From: Louise Crane
Sent: 18 May 2017 13:35
To: Planning.Responses
Subject: BR/74/17/PL

Comments from Environmental Health and Private Sector Housing:

Proposed Ground Floor Plan

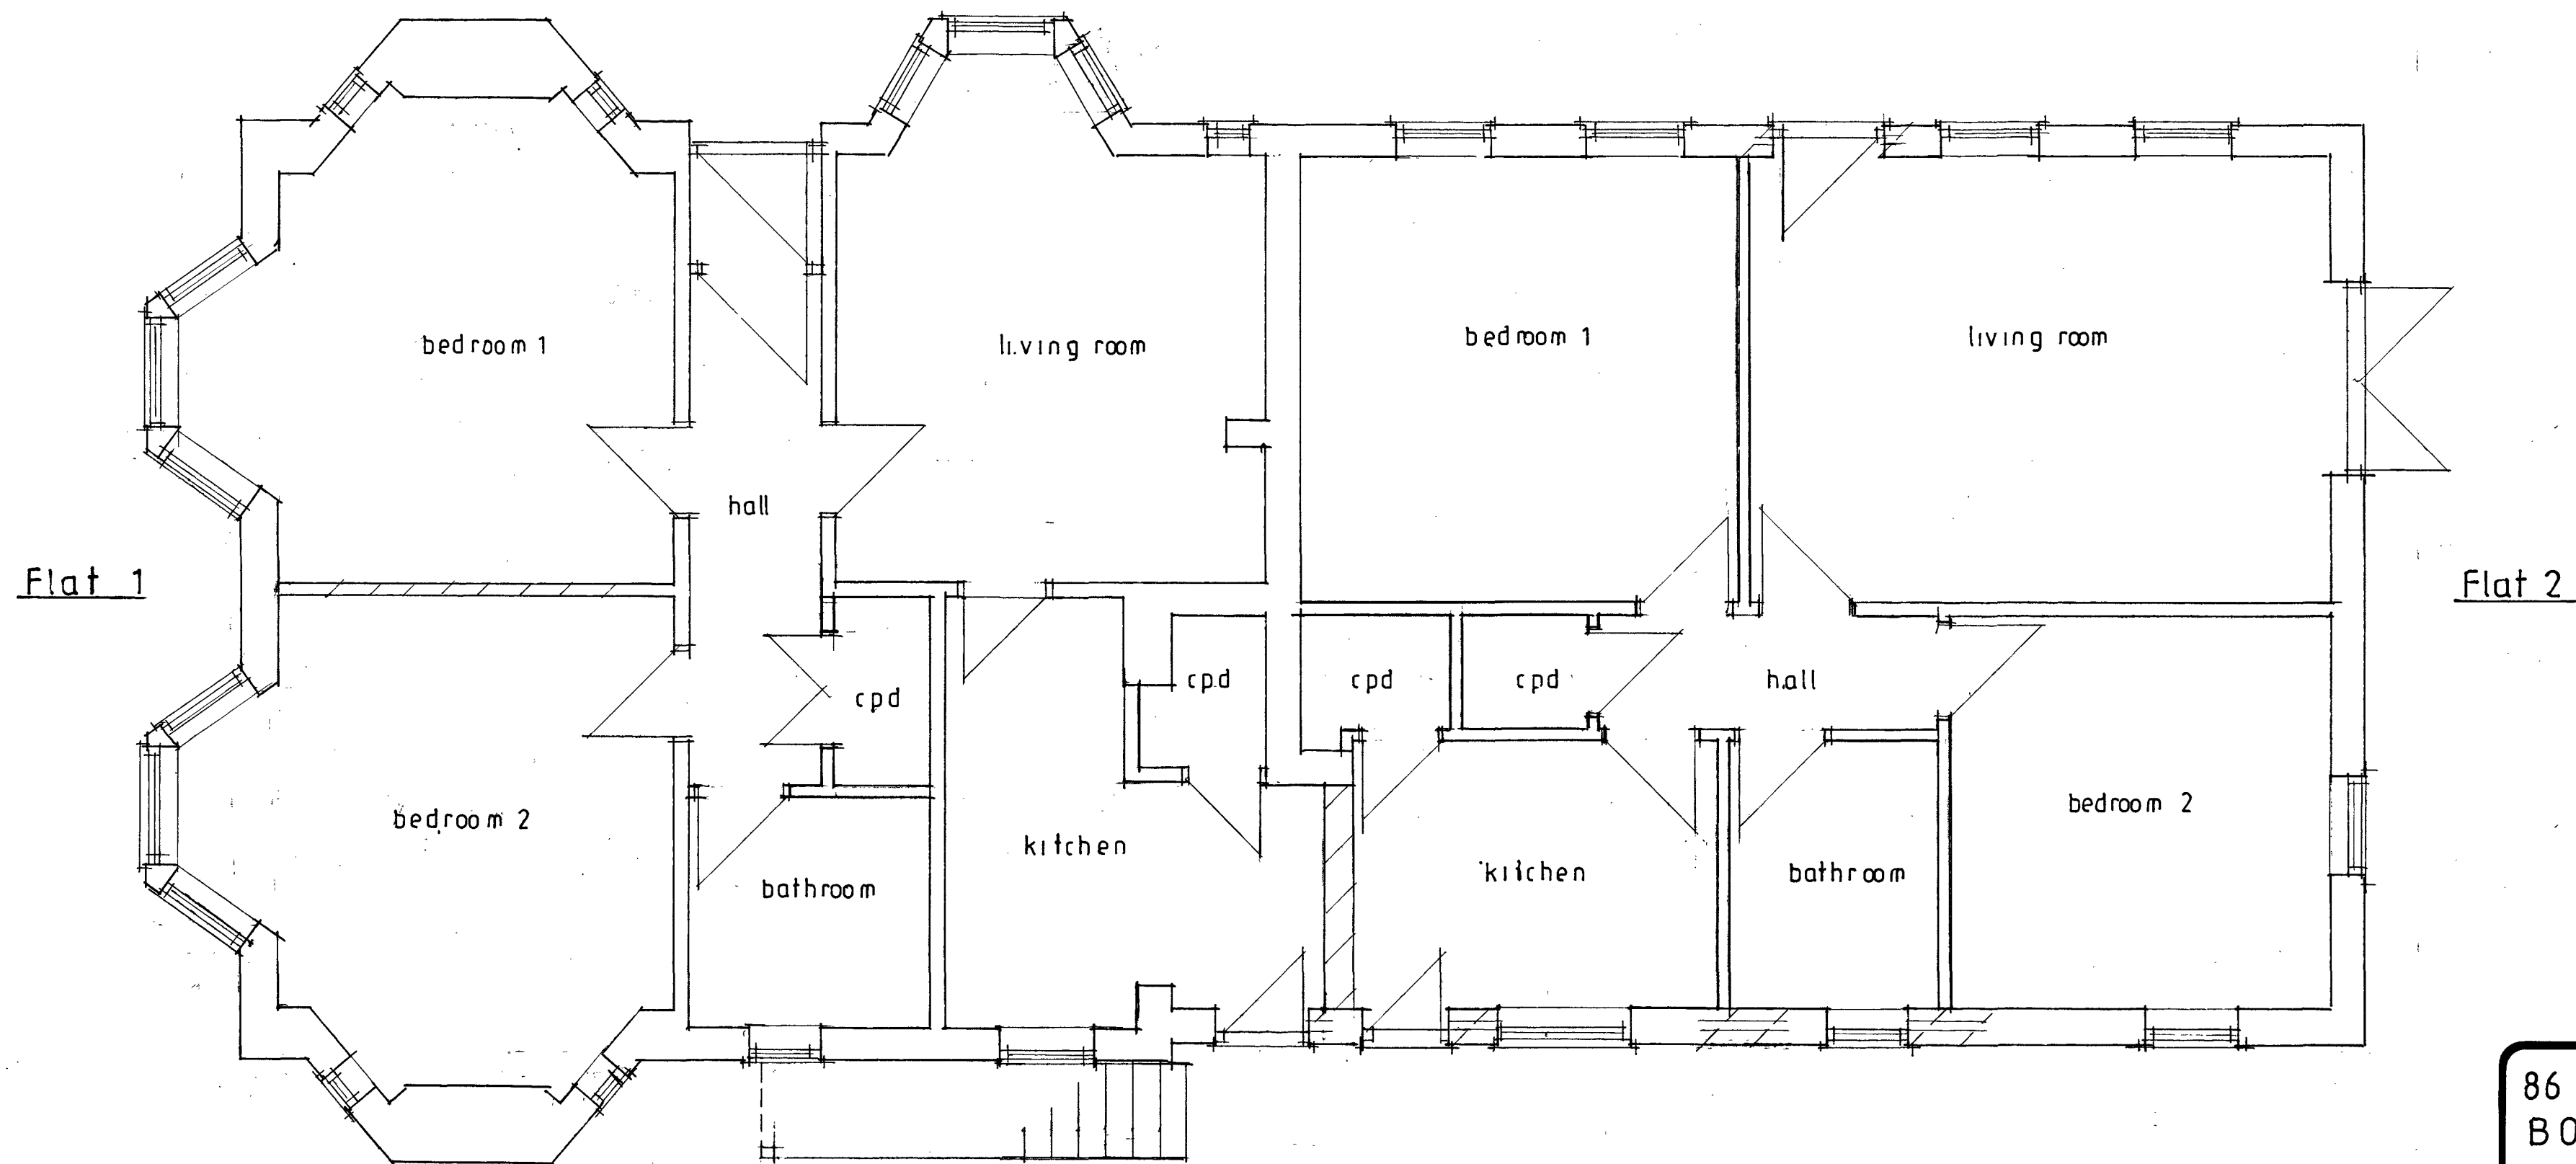
- Appropriate fire precaution facilities and equipment must be provided of such type, number and location as are considered necessary. Guidance on fire safety is contained in the LACORS guidance document – "Housing – Fire Safety, Guidance on fire safety precautions for certain types of existing housing"
- A room where the only escape route is through another room is termed an "inner room" and poses a risk to its occupiers if a fire starts unnoticed in the outer room. The escape routes from the bedrooms in Flat 2 is via the kitchen or living room, this can be overcome by ensuring that the window in the bedrooms are escape windows and adequate fire protection within the flat.

- Room sizes should meet the minimum standards for houses in multiple occupation if the flats are intended to be rented.
